Our Ref: R/2022/15/D
File No: 2024/503321
Your Ref: SSD-33258337-MOD-2

Request for Advice on Modification – Toga Central - SSD-332-58337-MOD-2

Thank you for your correspondence dated 16 August 2024 inviting the City of Sydney (the City) to comment on the Request for Advice on Modification in relation to MOD 2 – Design Development for the Toga Central development at 2-8A Lee Street, Haymarket.

Figure 4 Waste storage rooms

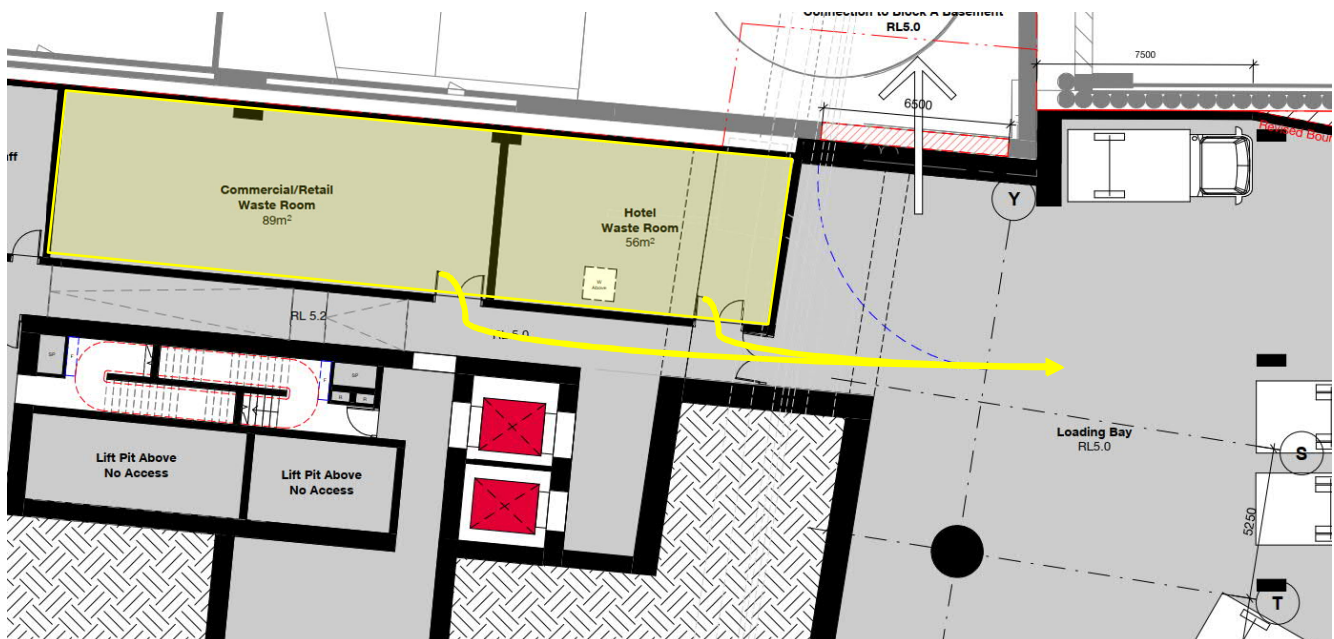
The original hotel waste storage area included space for bulky waste and equipment, such as a bin press, food dehydrator, crushed glass bins and a baler. The total space provided was 47.3sqm. It appears from the comments in the Waste Statement that TOGA has advised that its brief is to provide 20sqm of waste storage per 200 rooms as this will be adequate for the hotel.

The revised architectural plans show that the smaller waste storage area stems from the basement excavation of the site being significantly cut back.

- (a) Insufficient detail has been provided as to the layout and functionality of the hotel waste storage. The reduction in space of the hotel waste storage area does not provide for space requirements for the source separation of waste.
- (b) Confirmation is to be provided as to whether the proposed waste storage area changes will impact the building being able to achieve a minimum five-star Green Star Design and As built rating (version 1.3). Changes to waste storage area do not appear to be in-line with Green Star benchmarks in operational waste reduction by providing facilities to collect, process and store multiple waste streams.
